## RE: Ellensburg-Hungry Junction Short Plat (SP-08-00025)

The Kittitas County Community Development Services Department has determined that the Ellensburg-Hungry Junction Short Plat (SP-08-00025) is a complete application and hereby grants **conditional preliminary approval** subject to the following conditions:

ELLENSBURG-HUNGRY JUNCTION SHORT PLAT
PART OF SECTION 15, T. 18 N., R. 18 E., W.M.
KITKITAS COUNTY, WASHINGTON

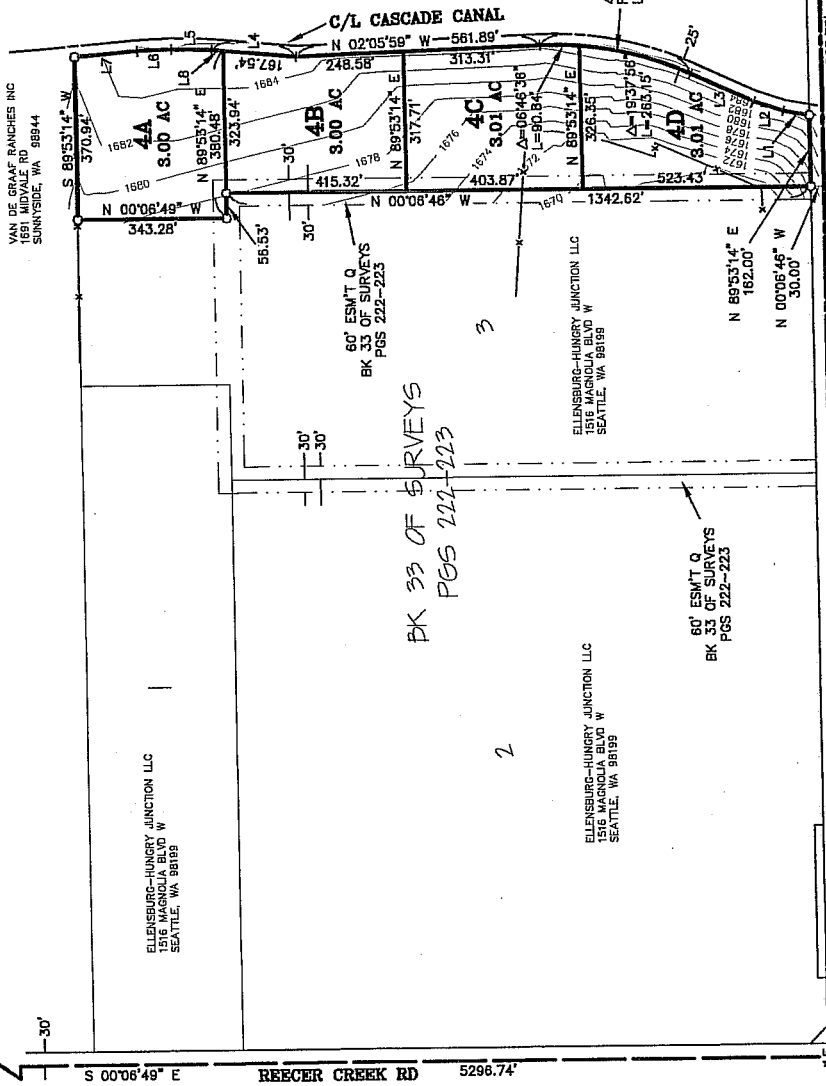
1. Both sheets of the final mylars shall reflect short plat number SP-08-00025 and an accurate legal description shall be shown on the face of the final plat.

2. Full year's taxes must be paid on all tax parcel numbers per requirement of the Kittitas County Treasurer's Office.
3. The Palustrine Emergent Saturated (PEMB) wetlands located on all lots shall be clearly delineated on the final mylars.

2. **Temporary Cul-de-Sac:** A temporary cul-de-sac turn-around having an outside right-of-way easement diameter of at least 110 feet shall be shown within the subject property on the final plat. When constructed, the driving surface shall be at least 96 feet in diameter. The temporary easement may be abandoned when the road is extended. Cul-de-sacs must also conform to the requirements specified by the 2006 International Fire Code. Contact the Fire Marshal regarding any additional cul-de-sac requirements.

3. **Private Road Improvements:** Access from Hungry Junction Road to the temporary cul-de-sac shall be constructed to meet or exceed the requirements of a High-Density Private Road that serves 3-14 tax parcels. No direct access to Hungry Junction Road will be allowed. See Kittitas County Road Standards, 9/6/05 edition.

- a. Access easements shall be a minimum of 40' wide. The roadway shall have a minimum width of 20', with 1' shoulders, for a total width of 22'.
  - b. Minimum centerline radius will be 60'.

- c. Surface requirement is for a minimum gravel surface depth of 6".
